Application for a non-material amendment following a grant of planning permission.

M/130/07

RETENTION of flat roof over side dormer in lieu of 11' 'Cot slide' roof as approved in order to achieve headroom and comply with building reqs

DH/6 rev C

Scale 1:100
 Drg no DH/6
 Rev A Feb 2008
 Rev B Jun 2009
 Rev C Feb 2010

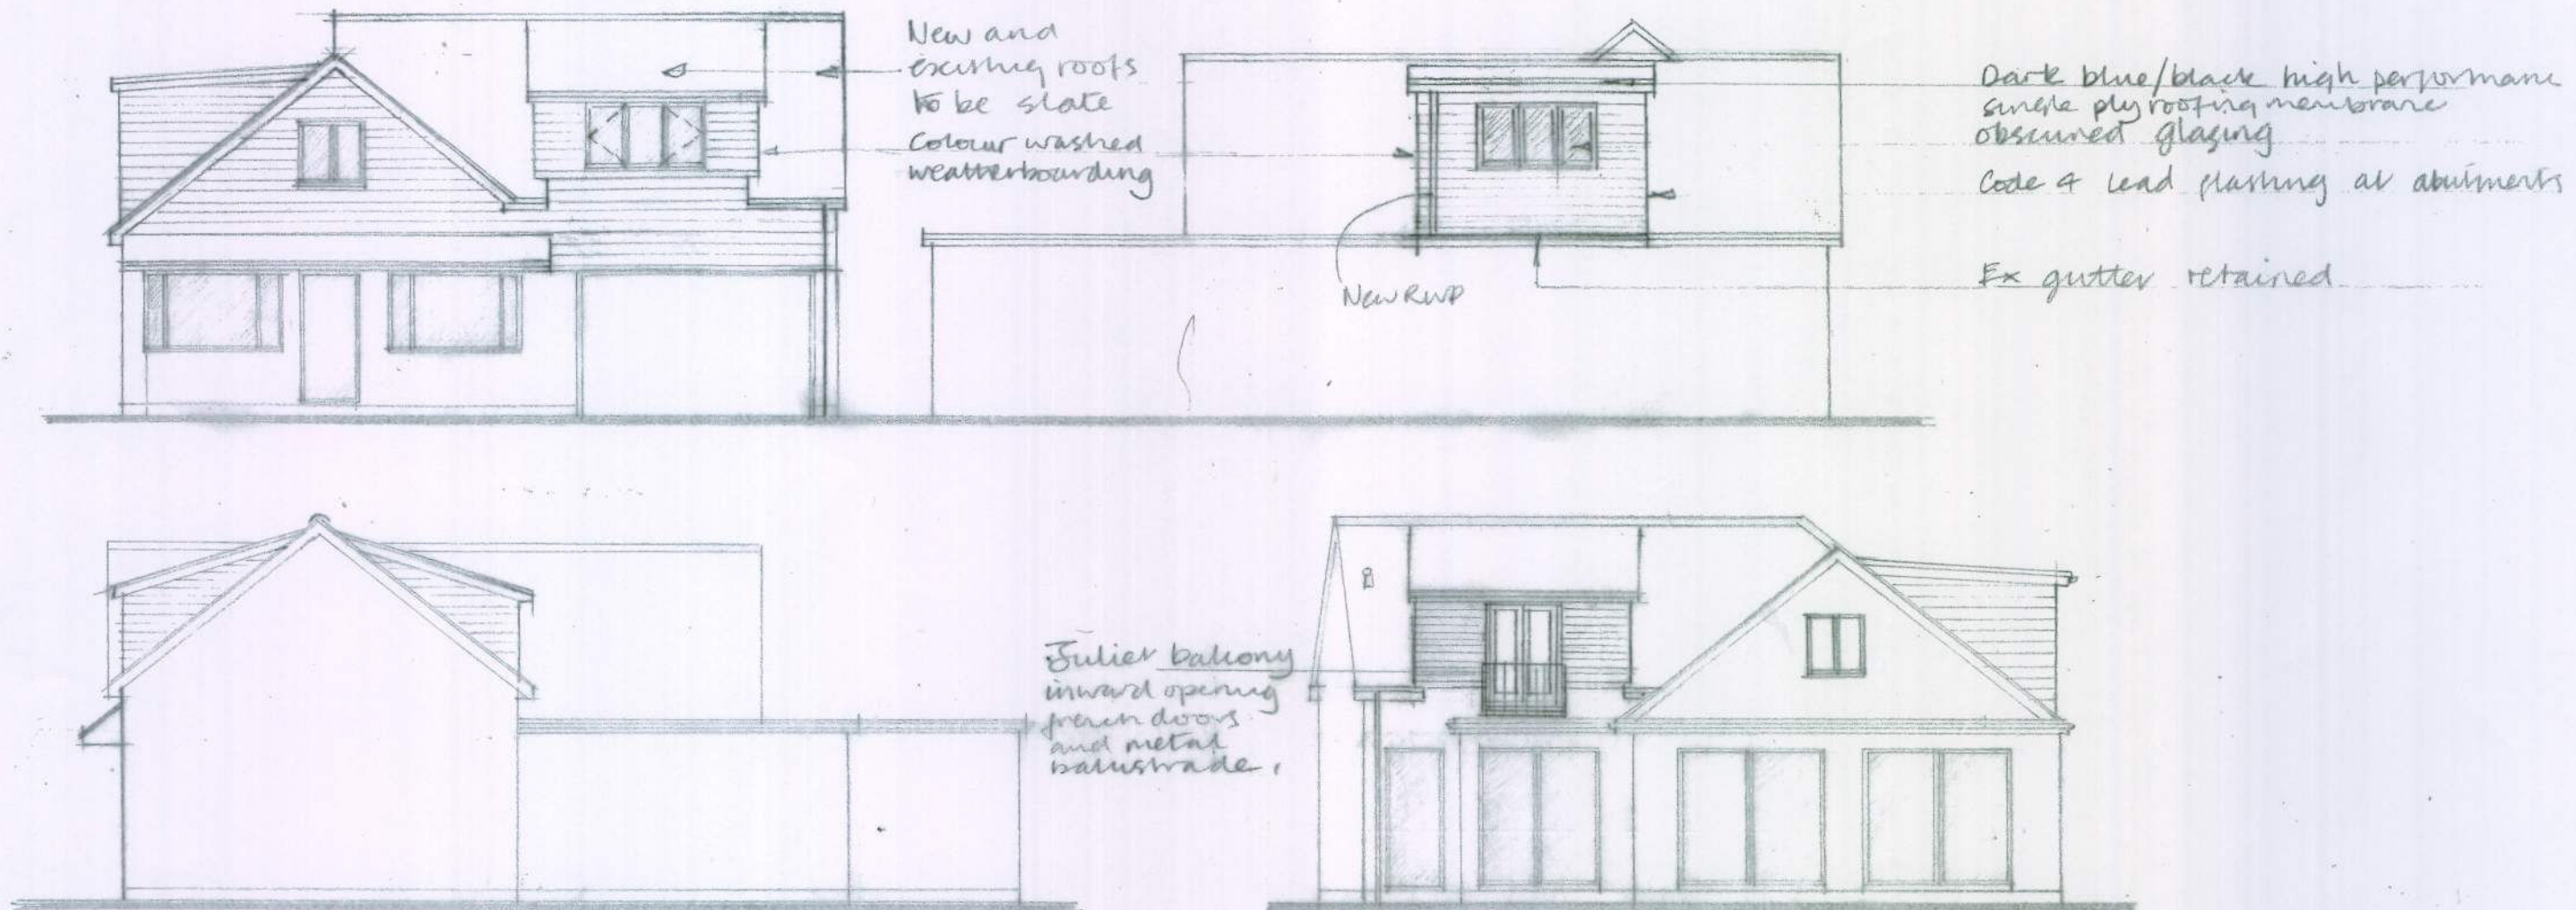
Retention of front elevation without short section of roof previously shown over garage door
